Botley West Solar Farm Ref: EN010147 -

Deadline 2: June 27th 2025 – Subsequent to Questions (ExQ1)

For the attention of the Planning Inspectorate. Our reference number: RR 0413

Revision of Submission Reference Number: 36569

Project			Status		
Botley West Solar Farm			Illustrative		
Id.	Changes	Date	Name	Date	Name
			Edit	31.10.2024	V. Guskova
			Check	31.10.2024	H. Trabelsi
			Drawing No	EN010147/APP/6.4	
A	Created	31.10.2024	VG

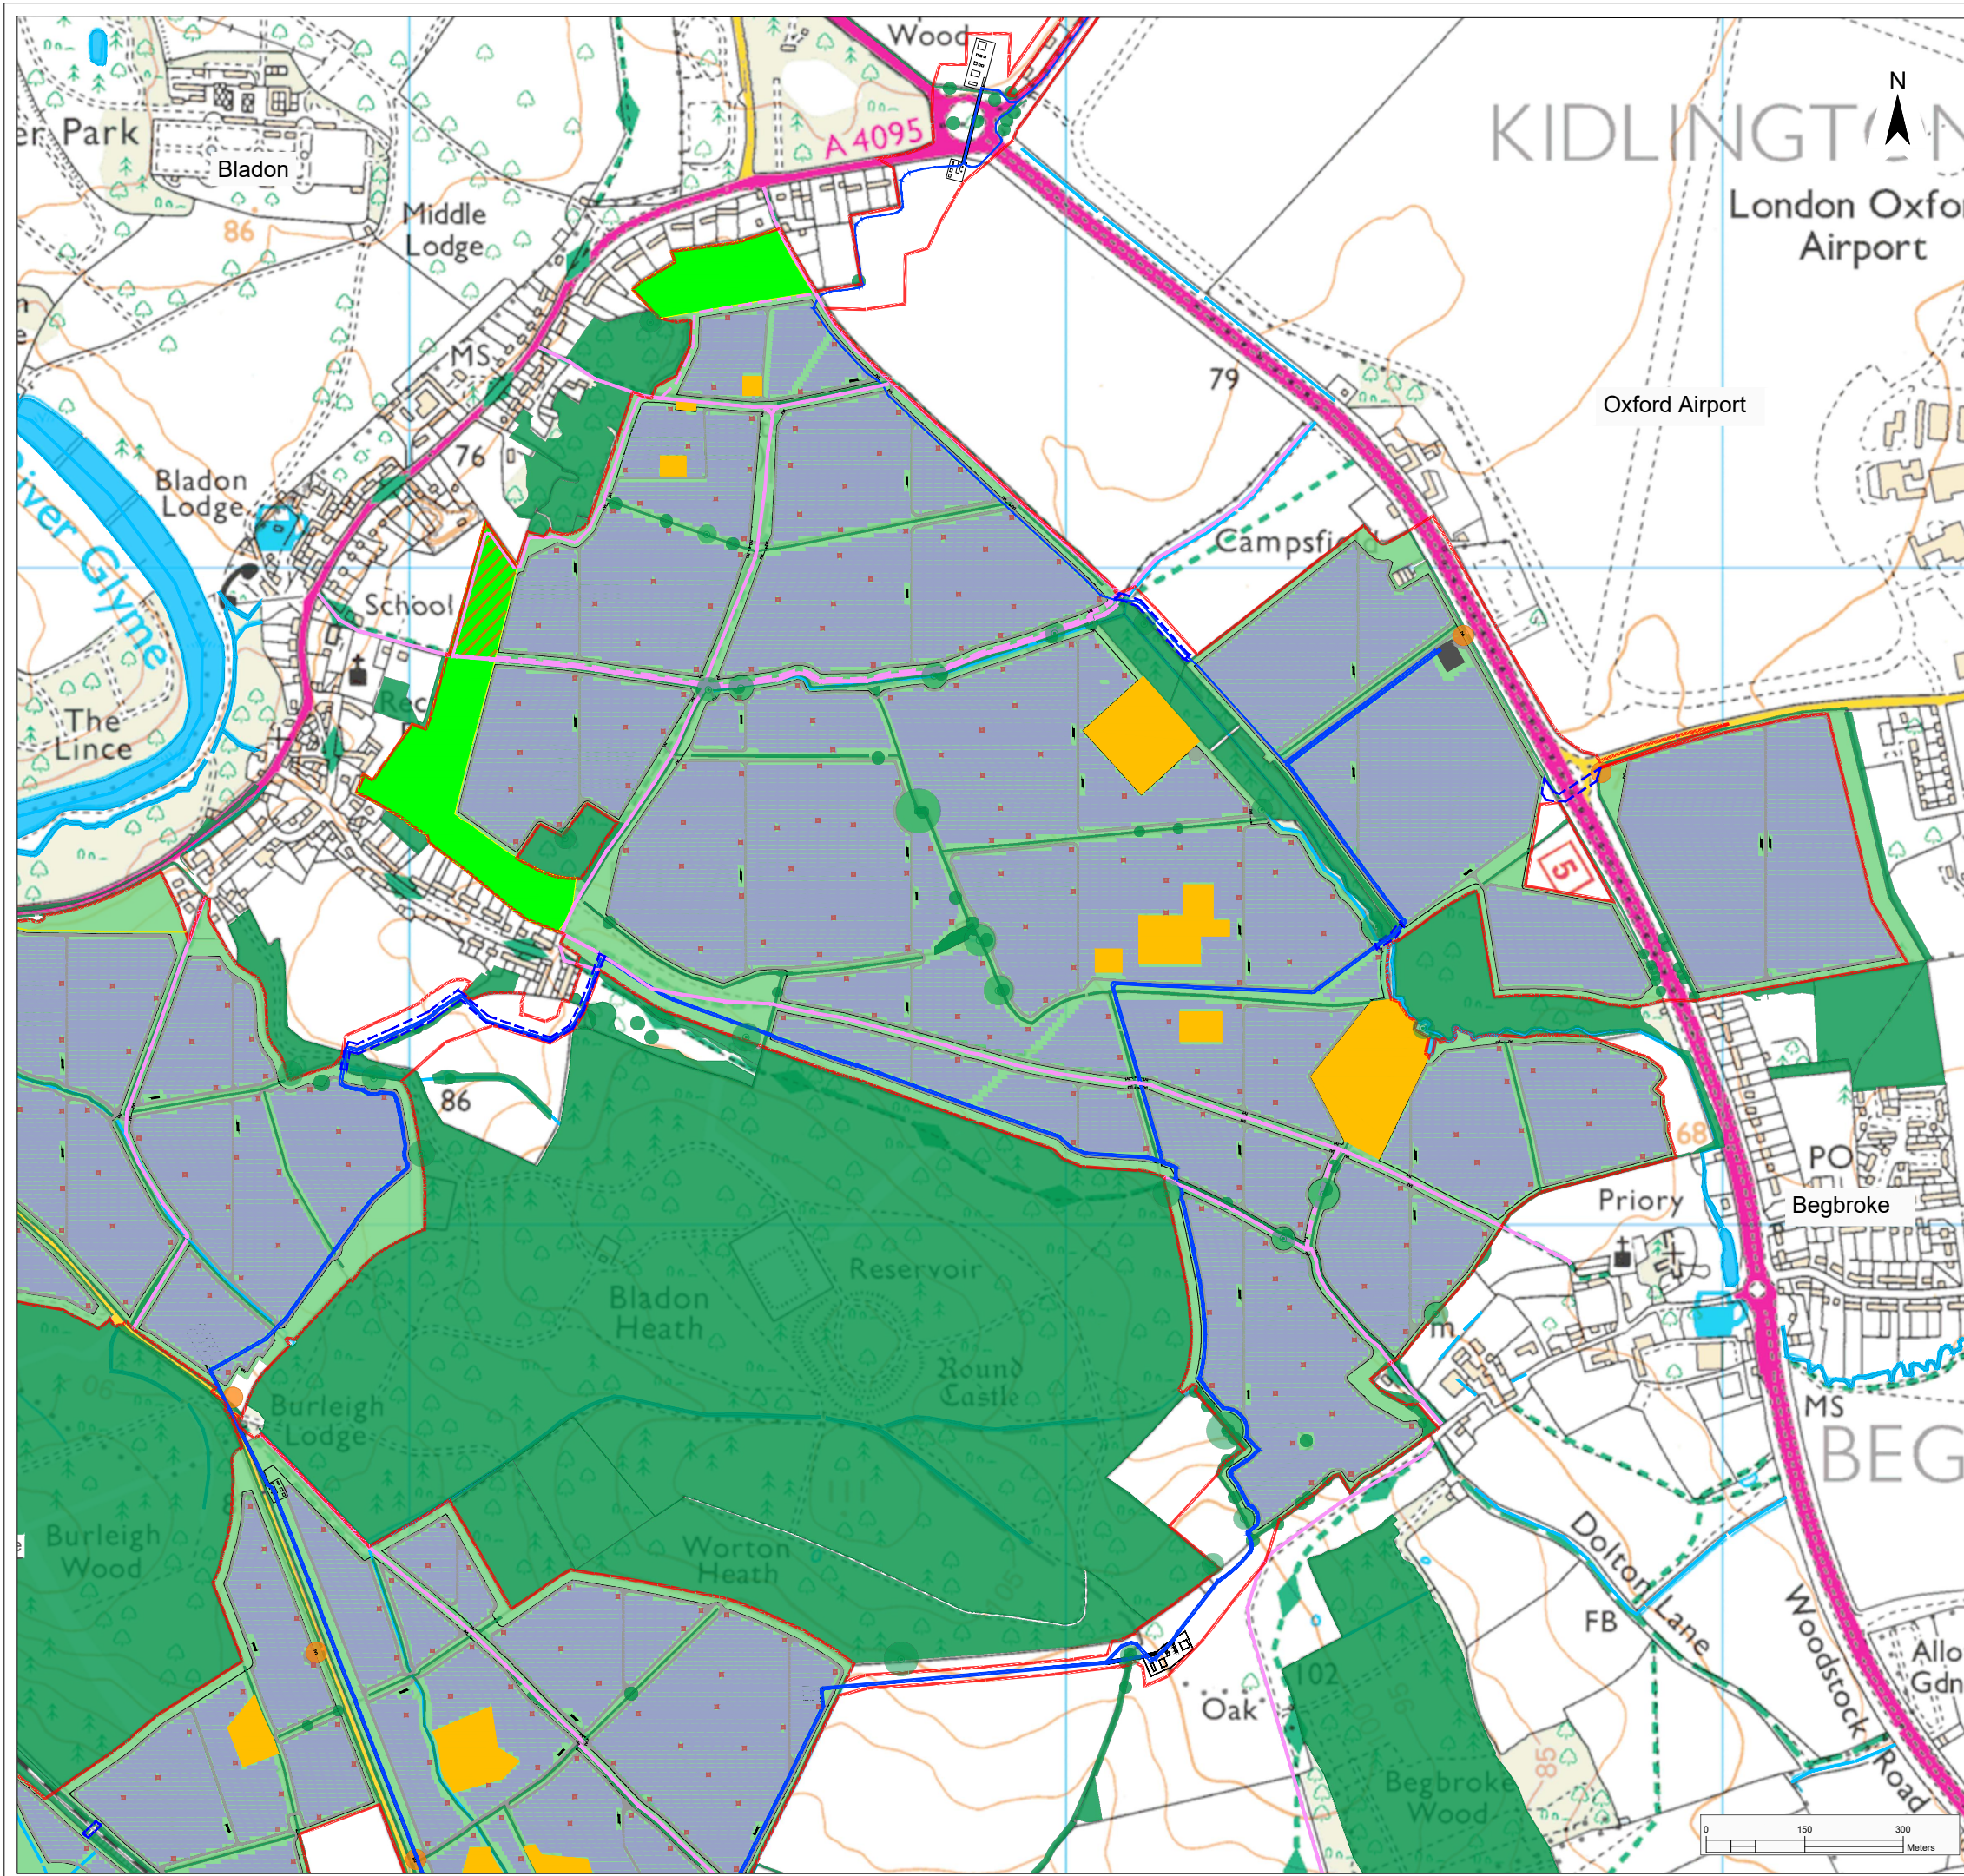
An exception to this is near Oxfordshire Way (Akeman Street) around Hordley and Sansoms farms, near the B4027 road and several public footpaths as well as 'Oxfordshire Way'. Here the land is dome shaped and visibly sloping. Therefore, **the south-eastern bays on Illustrative Masterplan Figure 2.1B and northwestern bays on Illustrative Masterplan Figure 2.1C should be omitted [note: it is assumed that the extensive Areas of Archaeological Interest around Sansoms Farm, where solar panels would be equally harmful to the rural landscape, are no longer part of the proposed Solar Farm].**

b. Adequate space needs to be provided around public footpaths. The land beside the existing wooded east/west footpath across the northern solar farm proposal (Figure 2.1B) is sufficient to substantially seclude the path from adjacent land and to include mature trees; it is 25m wide. Beside the Withy Clump footpath south-east of Bladon (Figure 2.2A), it is 7-10 m from the outside of the adjacent thick hedge to the edge of the wood beside the path. These dimensions suggest that footpaths with solar panels on both sides should, as a standard requirement, run in an unobstructed width of 20-25m between the access tracks outside the fences around solar arrays. Where a path has solar arrays beside one side at least 12m should be left as a buffer beyond the access track alongside solar array fencing. The recent

Project			Status		
Botley West Solar Farm			Illustrative		
Id.	Changes	Date	Name	Date	Name
			Edit	31.10.2024	V. Guskova
			Check	31.10.2024	H. Trabelsi
			Drawing No	EN010147/APP/6.4	
A	Created	31.10.2024	VG

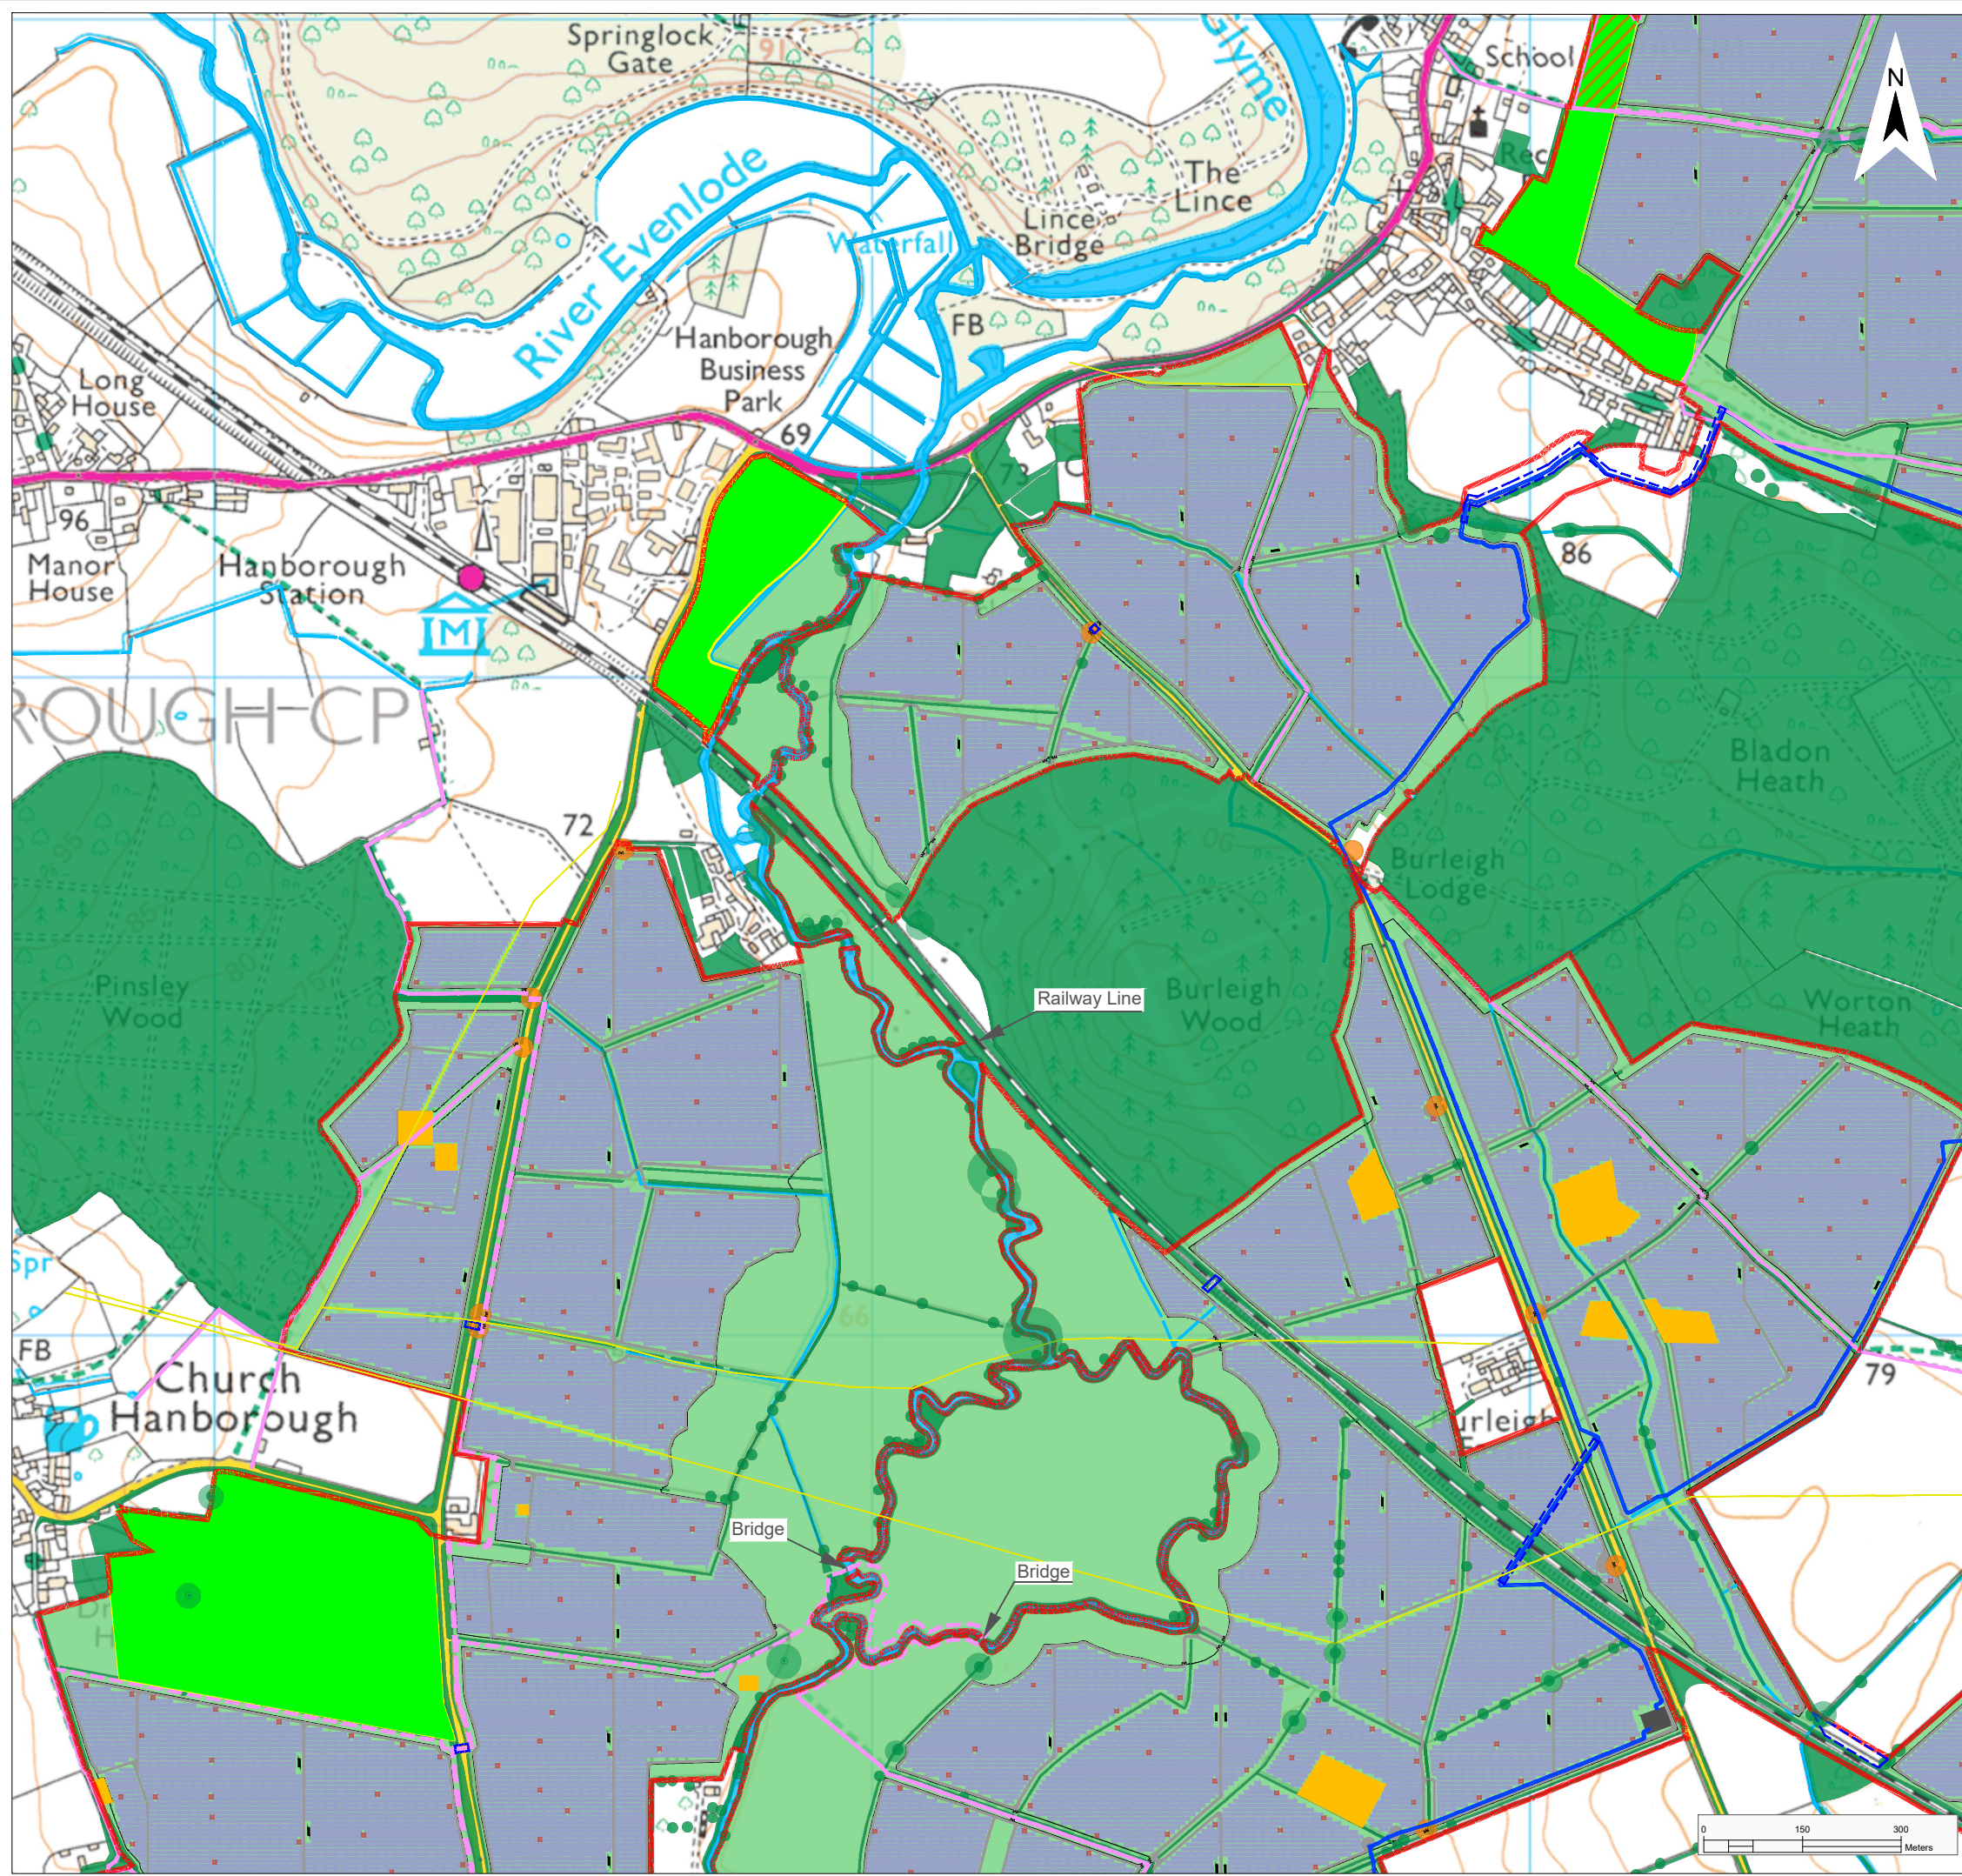
Shipton Slade hamlet abuts the southeast corner of the North Solar Farm. To reduce the sense of oppression by solar panels upon this hamlet **the whole of the easternmost field and a minimum 200m arc, only 3 minutes gentle walk, to the NW of the hamlet should be omitted and edged by a dense hedge. (Illustrative Masterplan Figure 2.1C – Northern Site Area).**
